March 14, 2019

Subject: Ziad Qudwa slaughterhouse – proposed design daily flow
1253 Atkins Road, Fuquay Varina
Project Number: 2019-04 / IP-43-1901

The initial review of the proposed DDF of 1,270 gallons per day (gpd) is complete. Based on the information provided, at this time we cannot concur with that figure. Review comments are as follows:

**FLOOR PLAN, DETAILS**

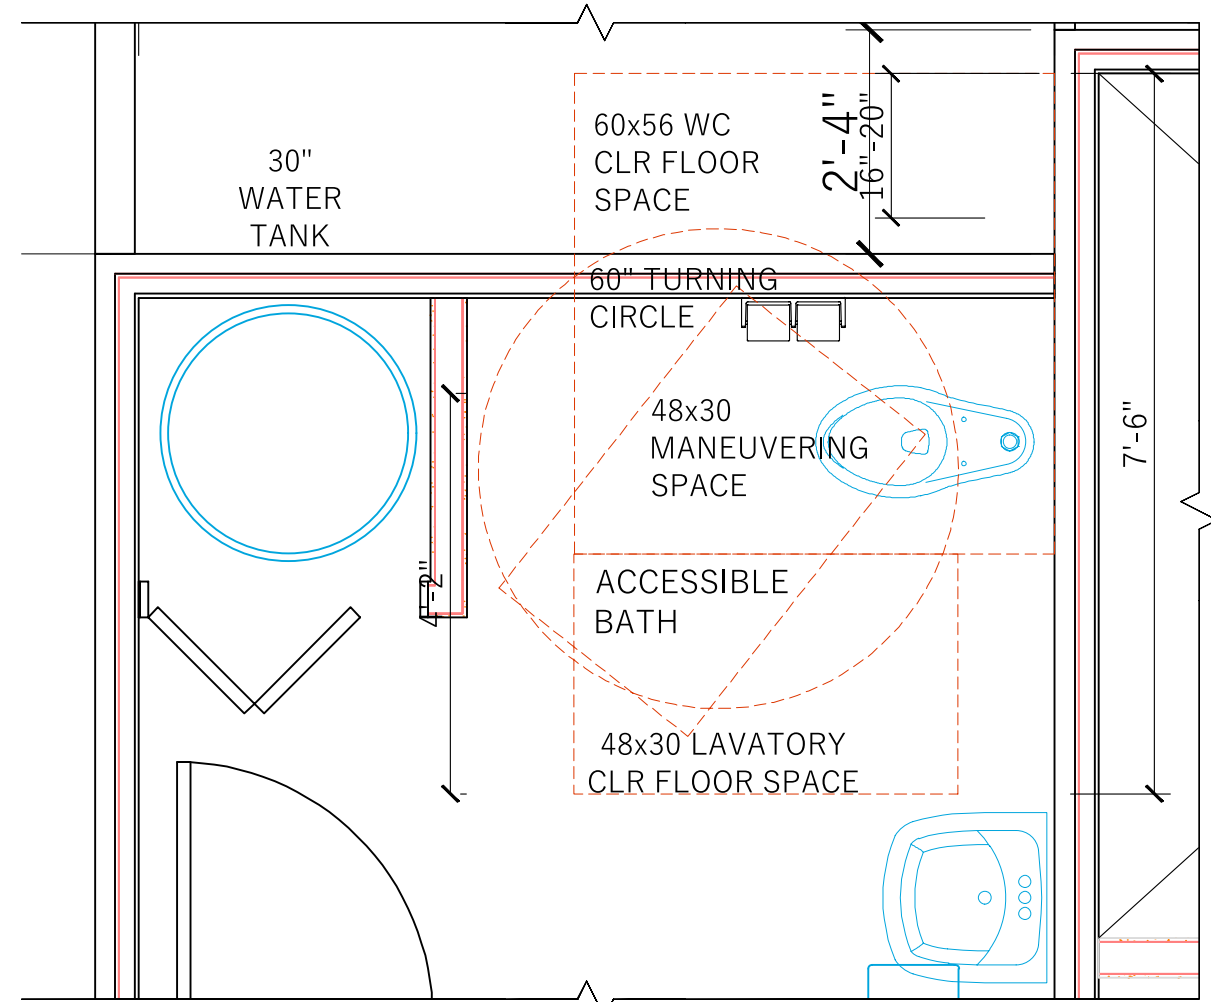
10. Blood and bodily fluids are not to be directed to floor drains in holding, slaughter, and processing areas for discharge to a subsurface wastewater treatment and dispersal system. Any such fluids are to be directed to a container for holding prior to offsite disposal.
